WELWYN HATFIELD COUNCIL – DEVELOPMENT CONTROL
DELEGATED REPORT

APPLICATION No:	S6/2008/0480/LB
------------------------	-----------------

The proposed development would involve the erection of a detached garage with accommodation within the roofspace. This addition would measure 14.5m in width by 6.2m in depth with a ridged roof to a maximum height of 7.5m. The northern and southern planes of the roof would have pitched roofed dormer windows measuring 1.5m in width by 3.0m in height. The flank elevations of this building would have an ornate design with circular windows. The agent has stated that the proposed side elevations are based on the lost curvilinear Dutch gables, which existed on the house before 1790. The garage has been illustrated to have a weather vane which would have a height of 8.6m from the adjacent ground level.

Great West Hyde House
 Garage 6103/2/10
 1:100 RT 14/11/07

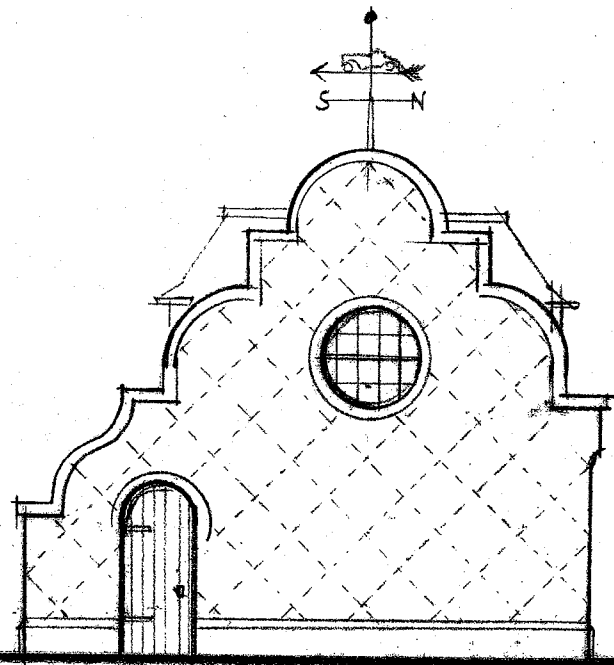
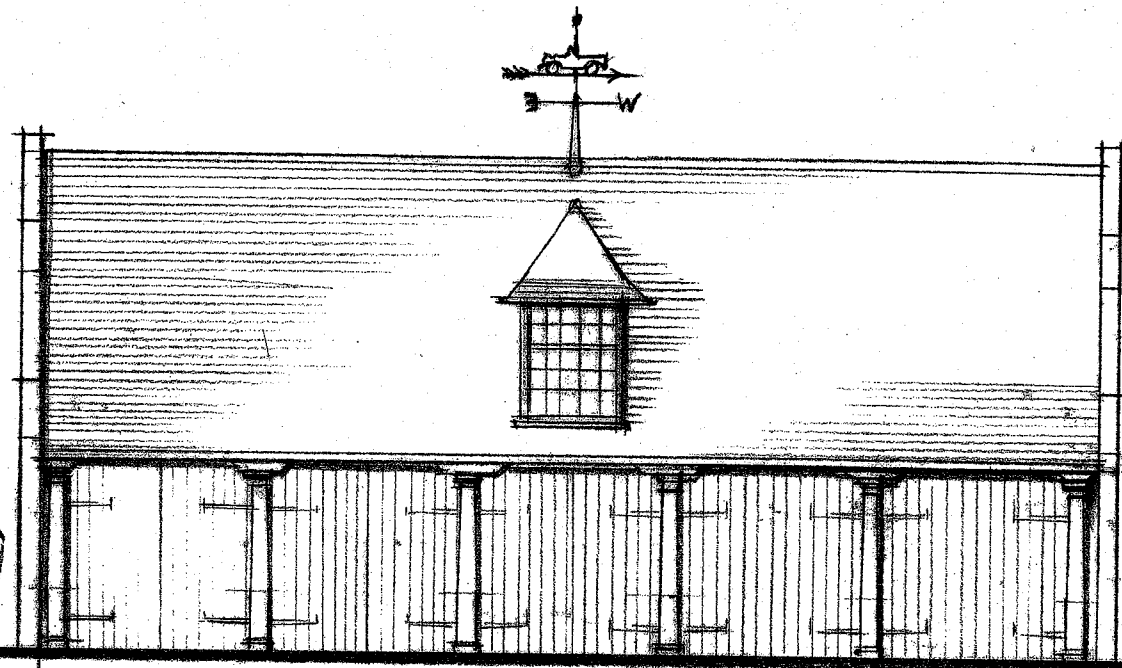
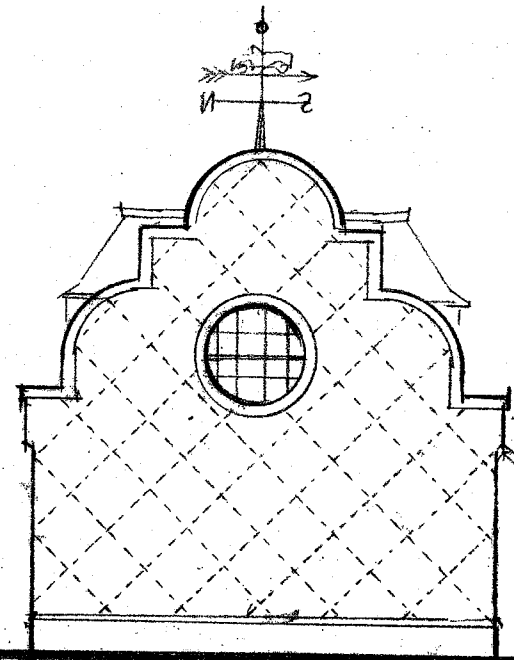
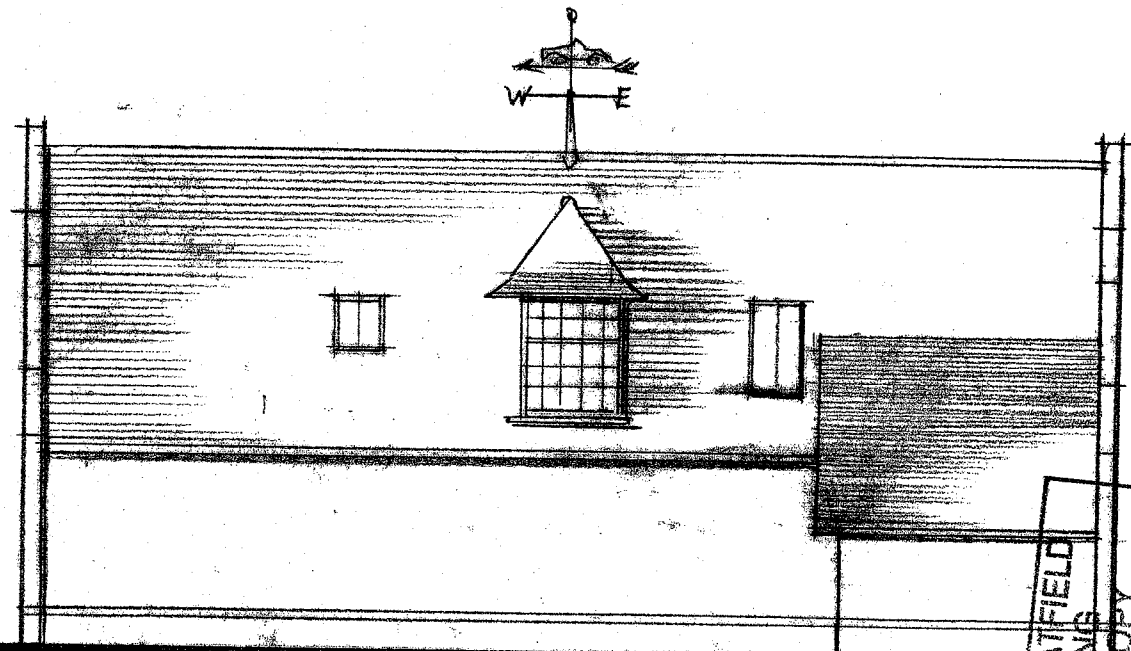
The proposed development would create a separate unit with residential accommodation above. Due to the design of the proposal it would have glazing at roof level, which would be noticeable from the surrounding area. The proposal would be viewed from Wilkins Green Lane and would be seen when approaching the main building. The proposed garage building would be within the same street scene and clearly be on the same plot as the main building. The proposal would have a maximum height of approximately 6.8m, which would mean that the building is viewed clearly above the adjacent boundary. Due to the proposed ornate design of the flank elevations and overall prominence of the building, it would have an adverse impact upon the setting of the main Listed Building. It has been acknowledged that the design has been based on a previous feature of the main building. However, this addition would not reflect the existing Listed Building and would not enhance its setting.

When considered cumulatively with the recently approved entrance gates and pillars the, the appearance of the proposal would be exacerbated. The proposed garage building would have an inappropriate design that would detract from the appearance of the Listed Building. The proposed building would also be excessive in terms of its mass, bulk and prominence. When considering with the proposed garages and proximity to the adjacent highway, it would have an adverse impact upon the character, appearance and setting of the Listed Building. The proposed development would therefore be contrary to PPG15.

The proposed garage outbuilding would form a prominent addition that would affect the character and appearance of the Listed Building. This addition would be easily viewed from the surrounding area and fail to preserve the attractive setting of the Listed Building. The proposed development has therefore failed to meet the requirements of PPG15.

The proposed detached garage would form a highly prominent structure within the immediate setting of the main house. The garage would detract from the appearance of the Listed Building and have a detrimental impact upon the existing character and appearance of the locality. There is insufficient evidence to justify such a significant change and harmful impact to their overall appearance. The proposal therefore does not comply with the requirements of PPG15 (Planning and the Historic Environment).

Parking & Indicative Garden plan

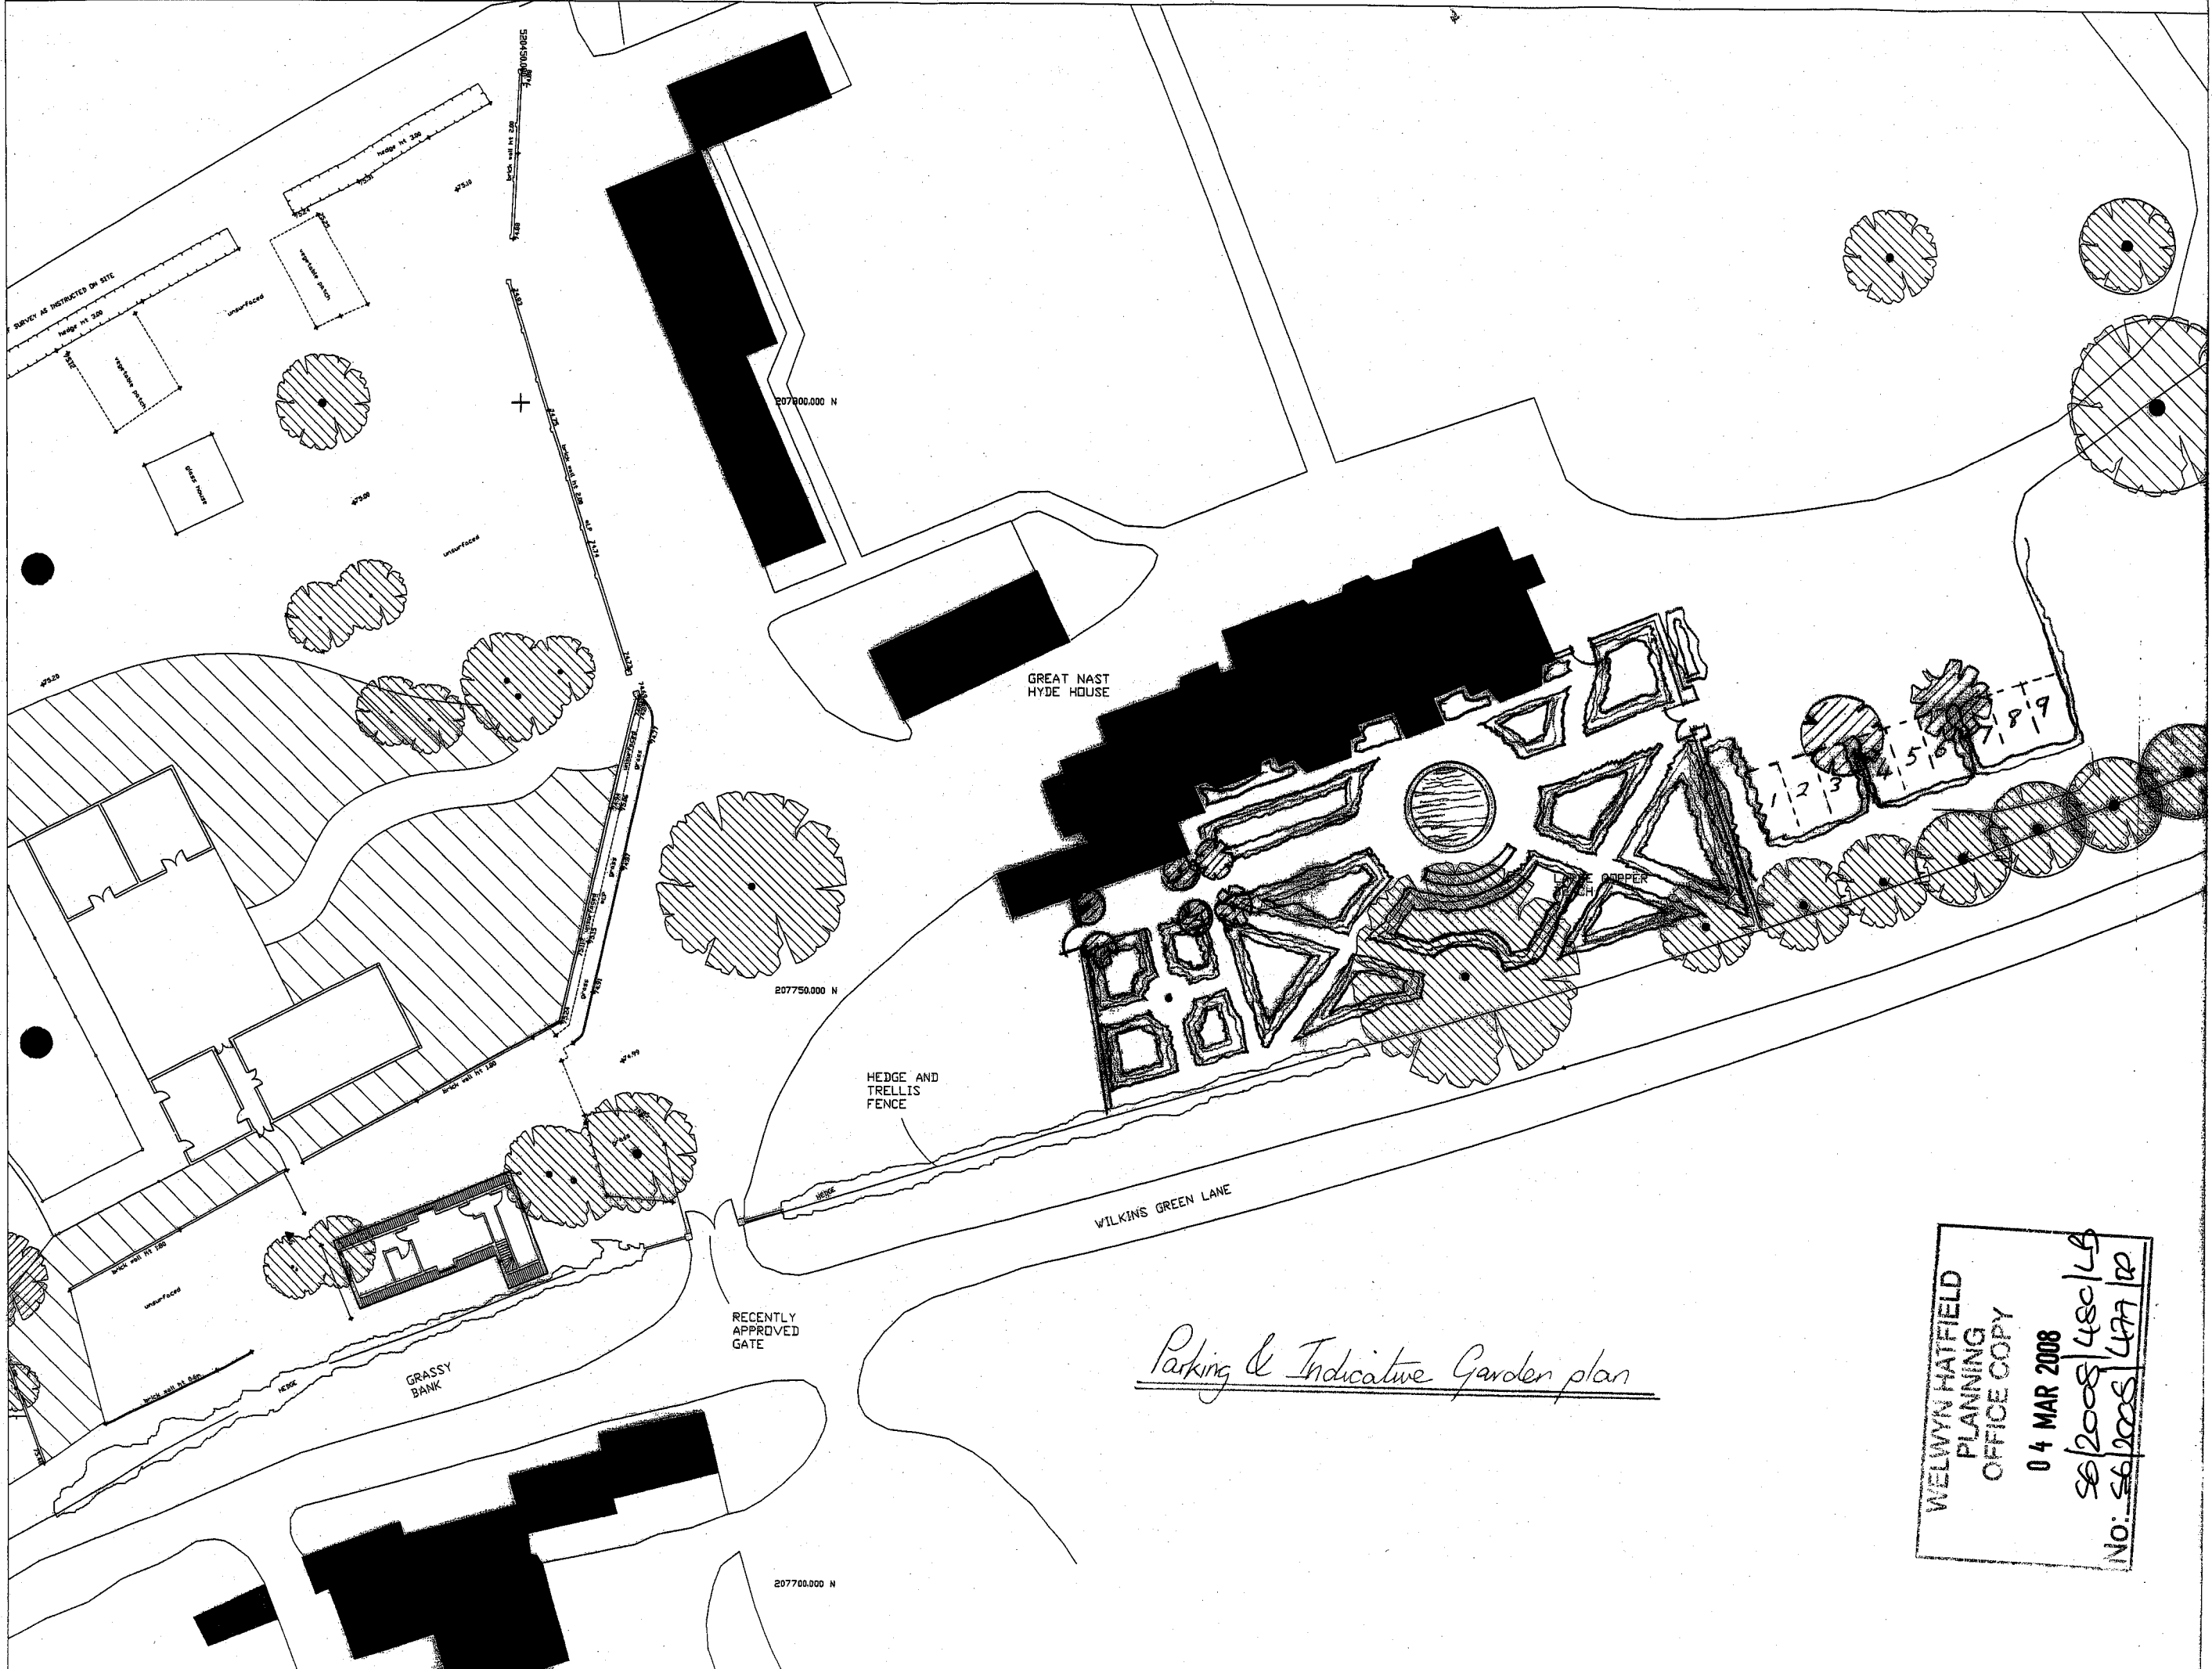
The proposed parking area would be sited beyond a screen of mature vegetation. The extension of the hardstanding to cover this area would not be viewed from the surrounding areas and would not have an adverse impact upon the character and appearance of the locality.

Elevation of Garden Wall as Existing

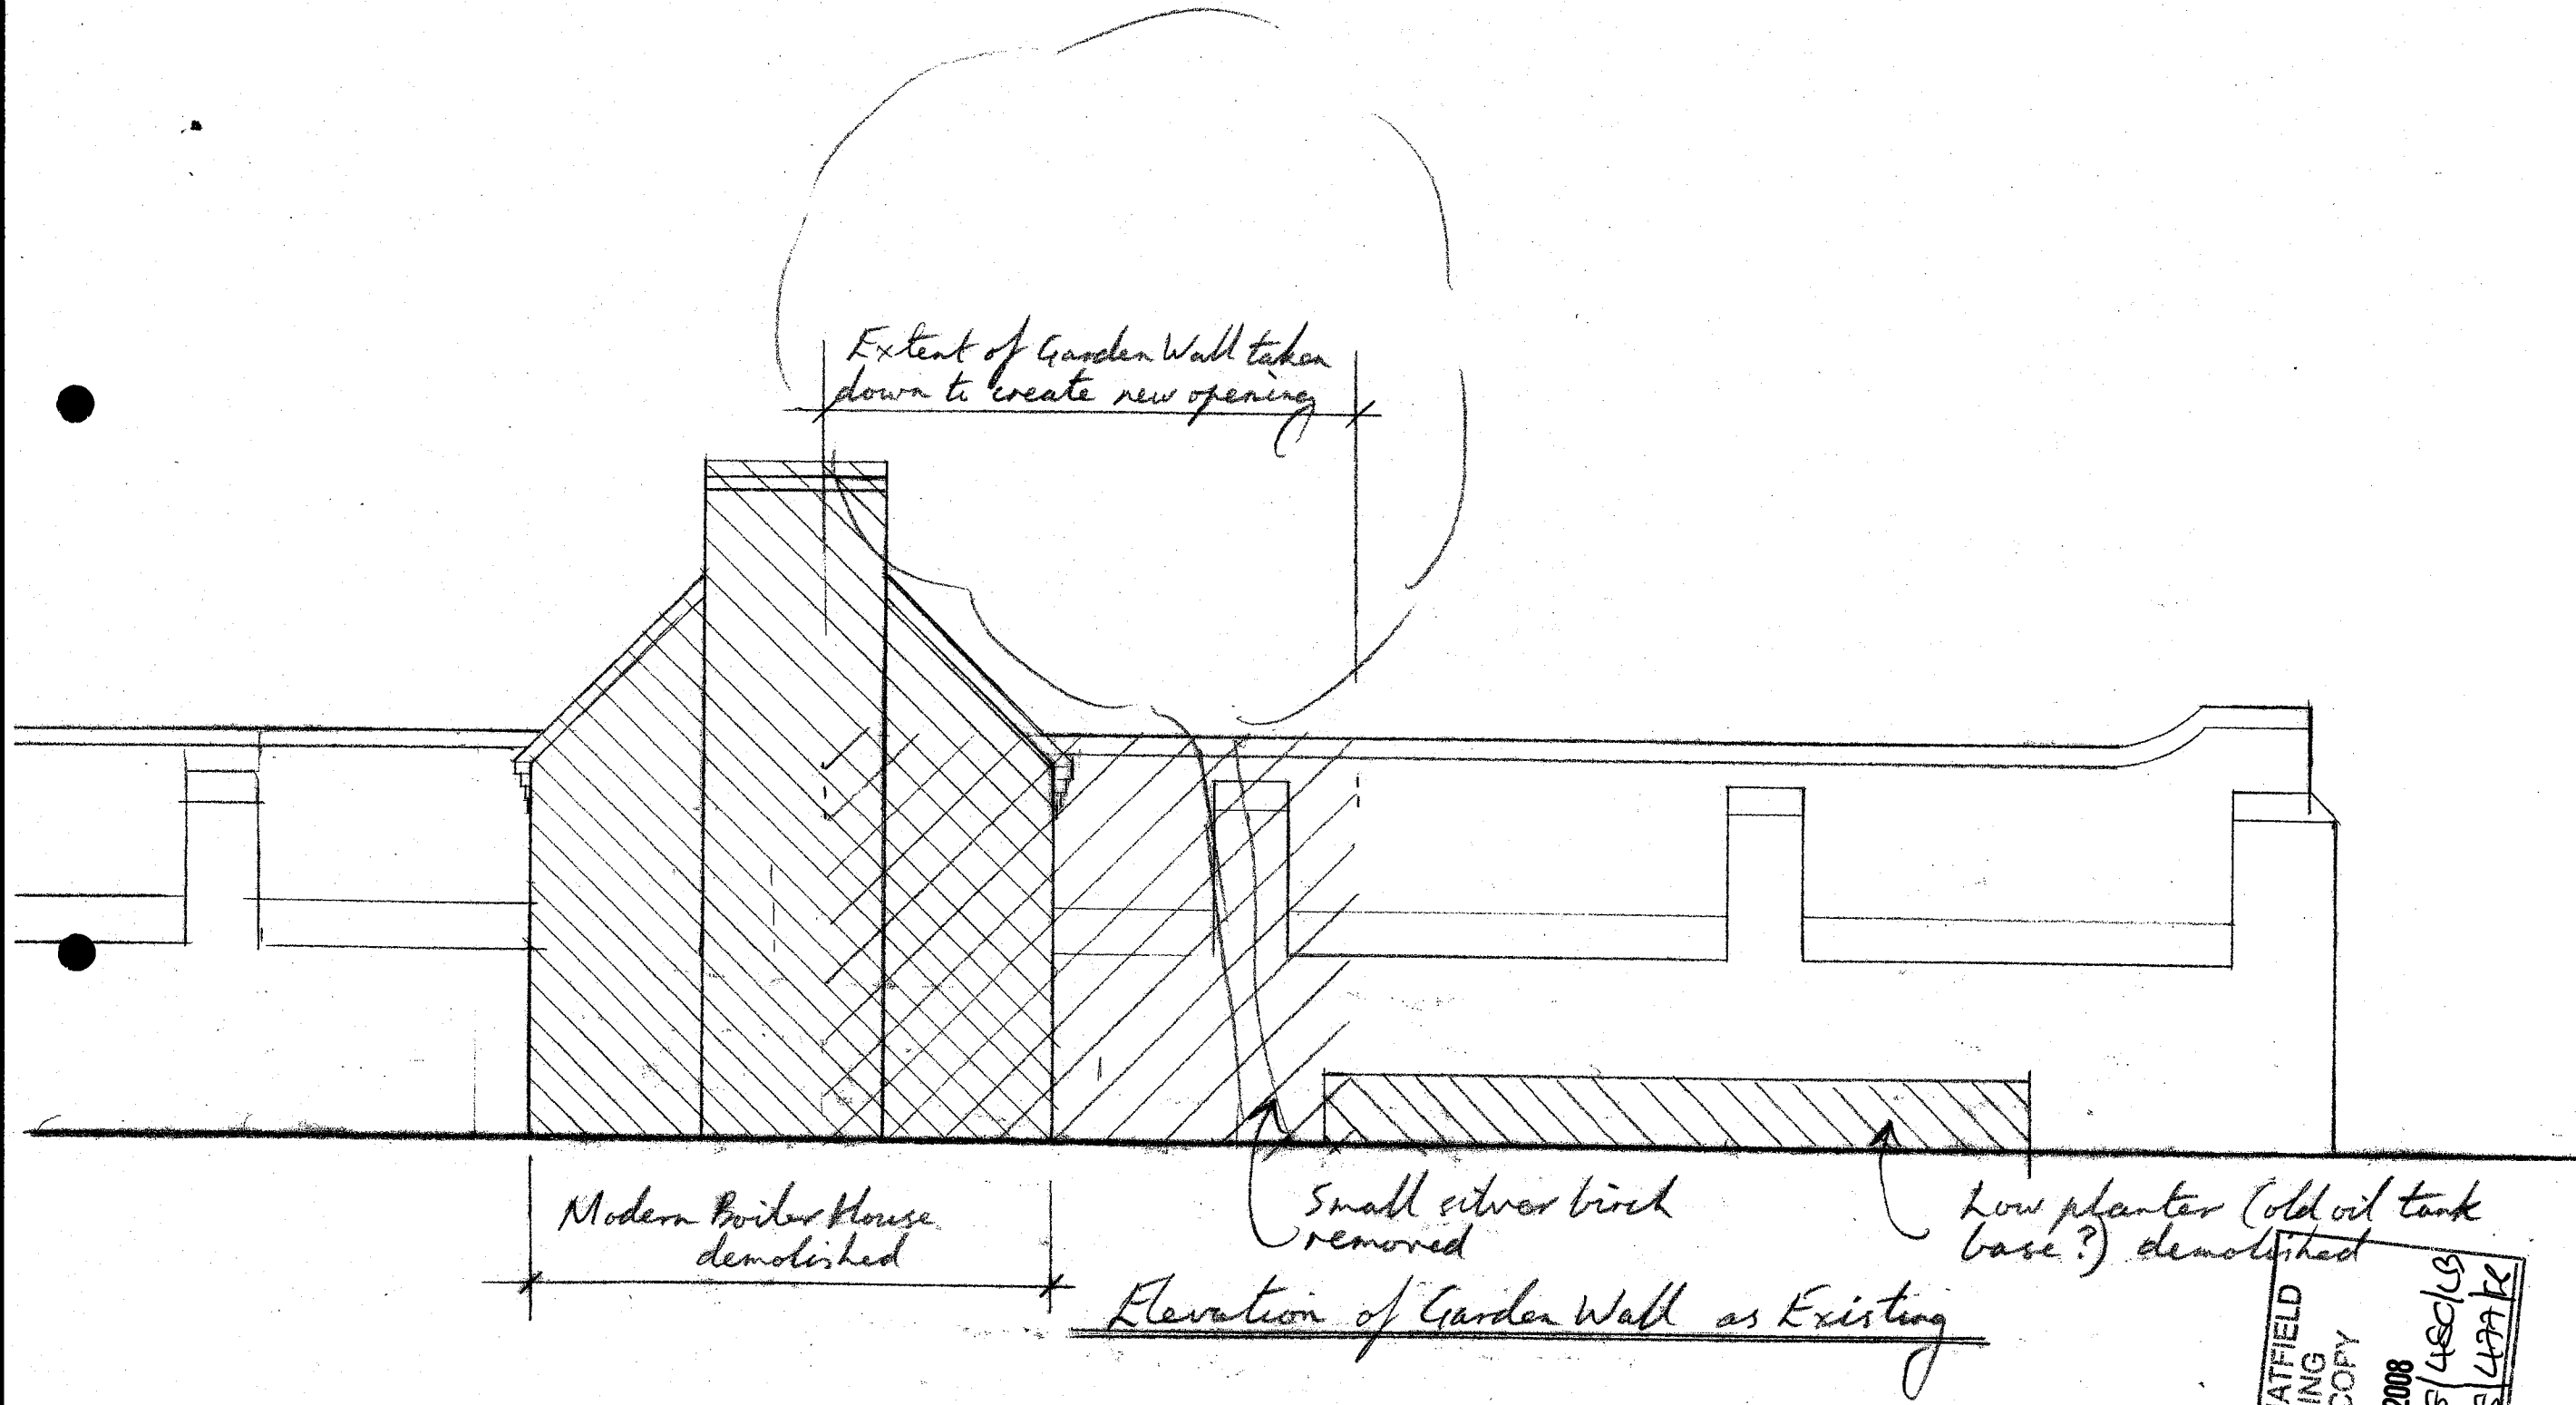
The proposed footgate would not have an adverse impact upon the appearance of the Listed Building. This addition would not have a significant height above the existing wall and would be adjacent to existing built development. The proposed design would be appropriate for the setting and would be in keeping with the recently approved entrance gates. The proposed footgate and the gates that were recently approved are intended to be convincing in terms of design, materials and scale. When compared to other historic properties the agent considers the proposed gates to be historically correct and convincing within the setting of the Listed Building. Due to the large area of land surrounding the proposal and trees and vegetation within view, the proposed gates would not appear particularly prominent.

The boiler house is a relatively modern addition which is not important to character and appearance of the Listed Building. The demolition of this addition would not have an impact upon the setting of the main Listed Building and would not affect the character of the area.
